<b>Application Ref:</b>	3/2025/0820			 <b>Ribble Valley Borough Council</b> <a href="http://www.ribblevalley.gov.uk">www.ribblevalley.gov.uk</a>				
<b>Date Inspected:</b>	15/10/25	<b>Site Notice:</b>	15/10/25					
<b>Officer:</b>	BT							
<b>DELEGATED ITEM FILE REPORT:</b>					<b>REFUSAL</b>

<b>Development Description:</b>	Variation of condition 2 (approved plans) of planning permission 3/2022/0791 to allow for alterations to fenestration and rooflight openings and introduction of microgeneration equipment.
<b>Site Address/Location:</b>	Twitter Bridge Farm, Twitter Lane, Waddington, BB7 3LG.

Side Elevation (South-West)

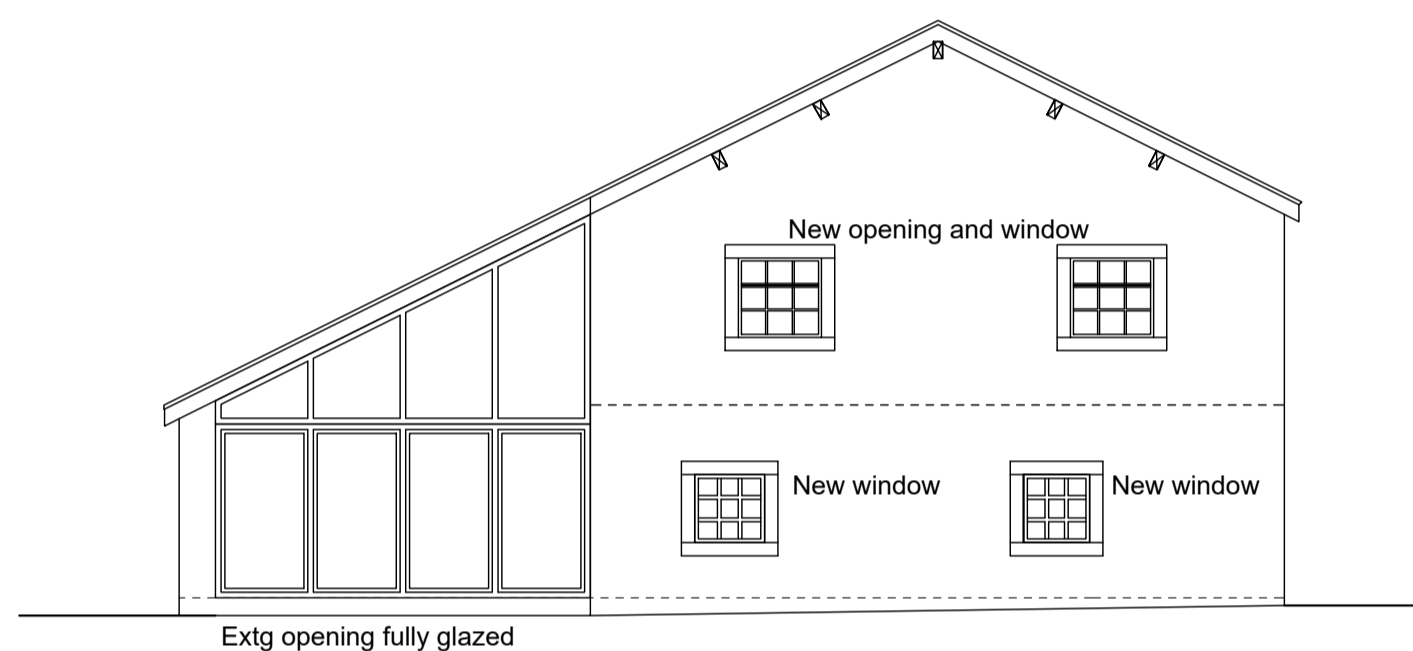
In this instance, the principal and rear elevations of the barn building would remain unchanged from the originally approved development however the proposed development includes some discernible deviations from the original approval. These changes include the addition of a full height glazed opening to the South-western elevation of the barn's outshut in place of a previously approved glazed and cladded opening and the introduction of four new window openings to the barn's currently featureless North-eastern gable which would be aligned a somewhat regimented fashion. In addition, whilst a reduced quantity of rooflights is proposed for the rear roof slope of the barn relative to the original consent, these would be aligned in an overtly regimented fashion in place of the randomised layout of rooflights approved previously. Furthermore, the proposal seeks to introduce integrated solar panels to the entirety of the barn's front roof slope which would significantly alter the character and appearance of the barn's principal profile. Consequently, it is considered that the proposed variations would cumulatively result in a development that would be substantially different to that originally approved in terms of design and external appearance and are therefore not considered to fall within the realm of a minor material amendment.

Side Elevation (North-East)

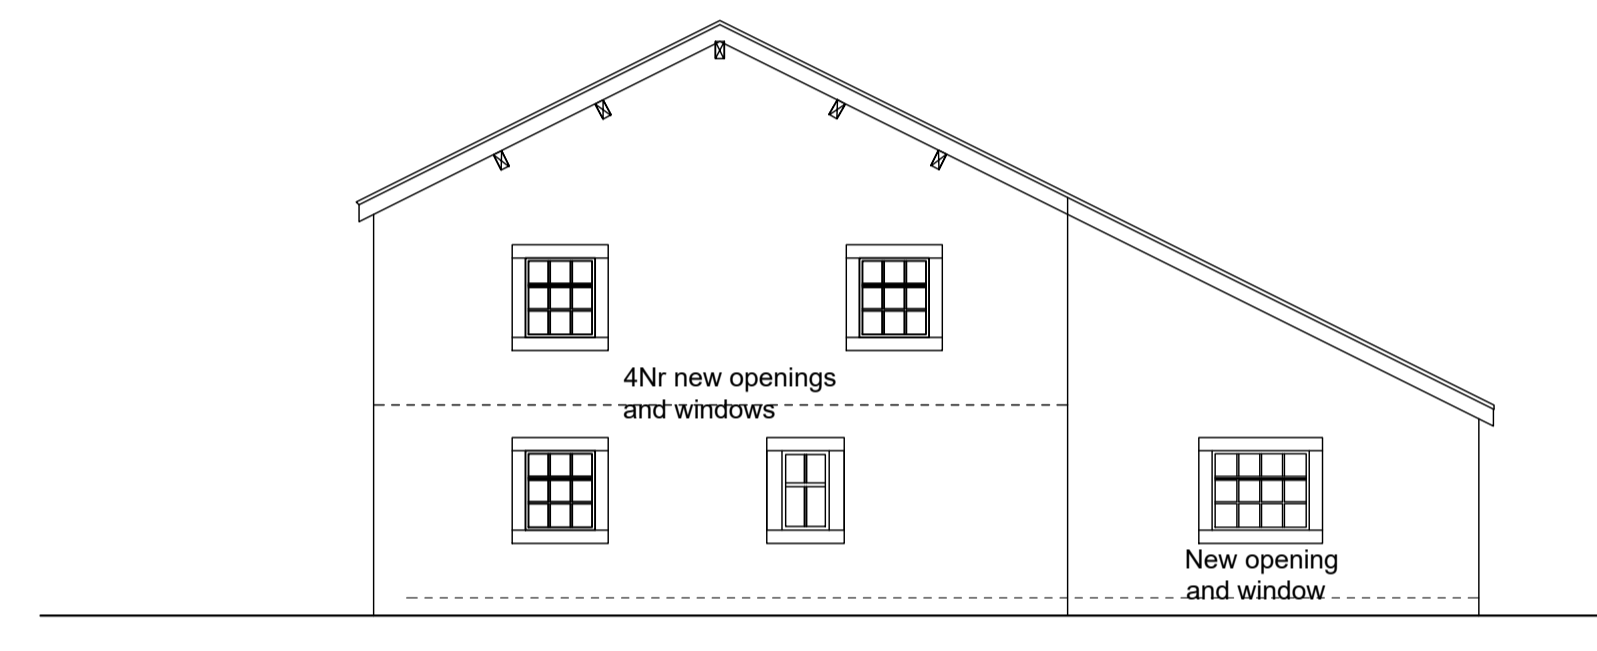
In this instance, the proposed development seeks to introduce four new window openings to the North-eastern gable of the barn building which would face away from the neighbouring property of Twitter Bridge Farm into open fields. In addition, the window and door openings proposed for the remaining elevations of the barn building would largely reflect the window and door layout approved under previous application 3/2022/0791. As such, the proposed development would not compromise the privacy of the sole neighbouring receptor on site.

Furthermore, the proposed full height glazing, regimented sequence of window and rooflight openings and microregeneration equipment would read as overtly domestic features in the context of the barn building's traditional character and open countryside setting, with the new window openings proposed for the barn's North-eastern gable also resulting in the loss of historic building fabric. Moreover, the proposed works would be largely visible in the public realm from both Twitter Lane and Public Right Of Way FP0343018 which flanks the North-eastern side of the barn building and would therefore carry a discernible visual impact.

Roof Plan

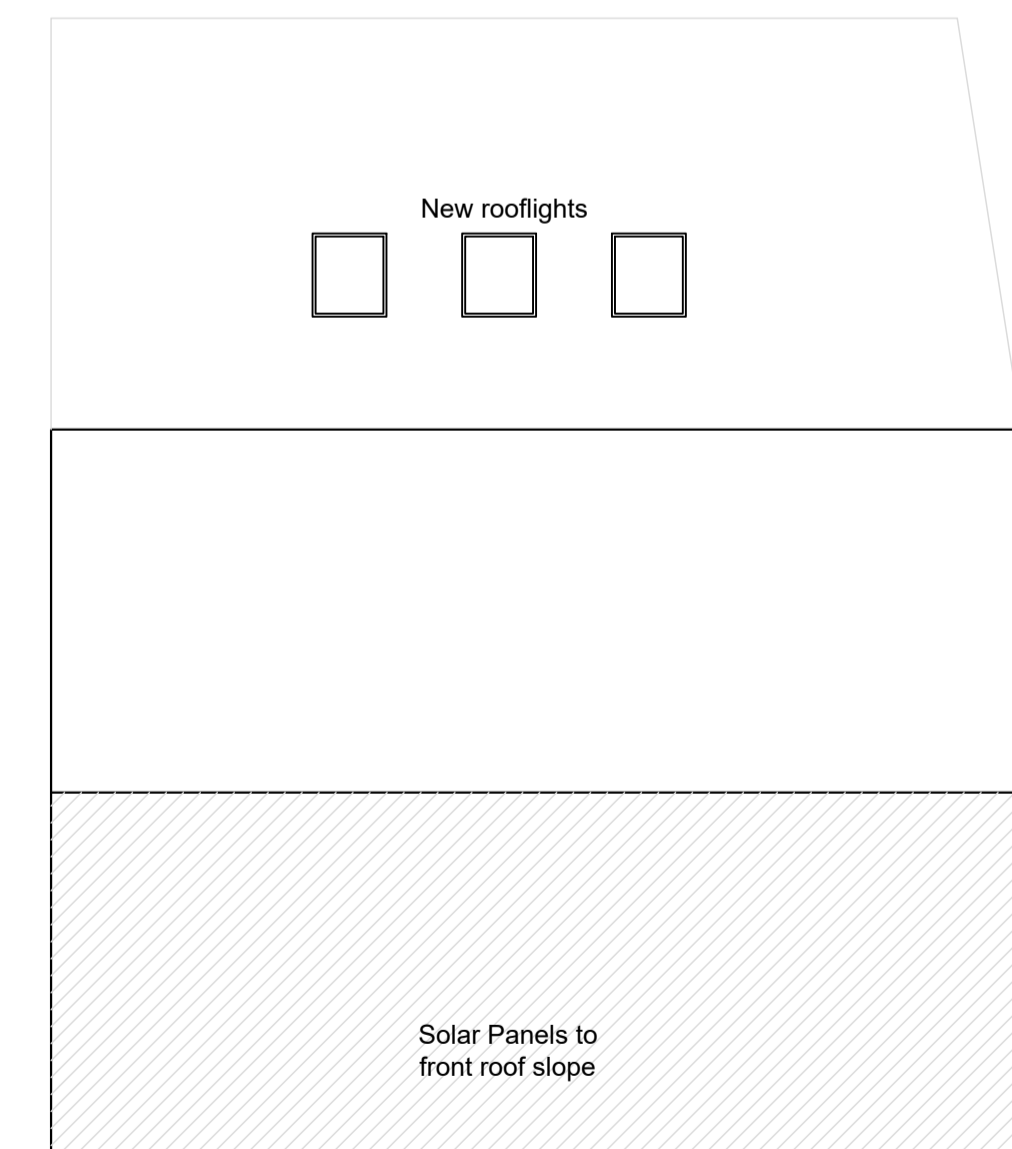
Accordingly, the proposed development by virtue of its fenestration, introduction of new window openings, loss of historic building fabric and use of microregeneration equipment would constitute an incongruous and unsympathetic form of development which would detract from the historic character of the barn building and visual amenities of the area. As such, the proposed development would have a harmful urbanising impact that would neither enhance or conserve the visual amenities of the surrounding National Landscape and would therefore fail to satisfy the requirements of Paragraph 135 (c) and 189 of the NPPF and Key Statement EN2 and Policies DMG1, DME5 and DMH4 of the Core Strategy.
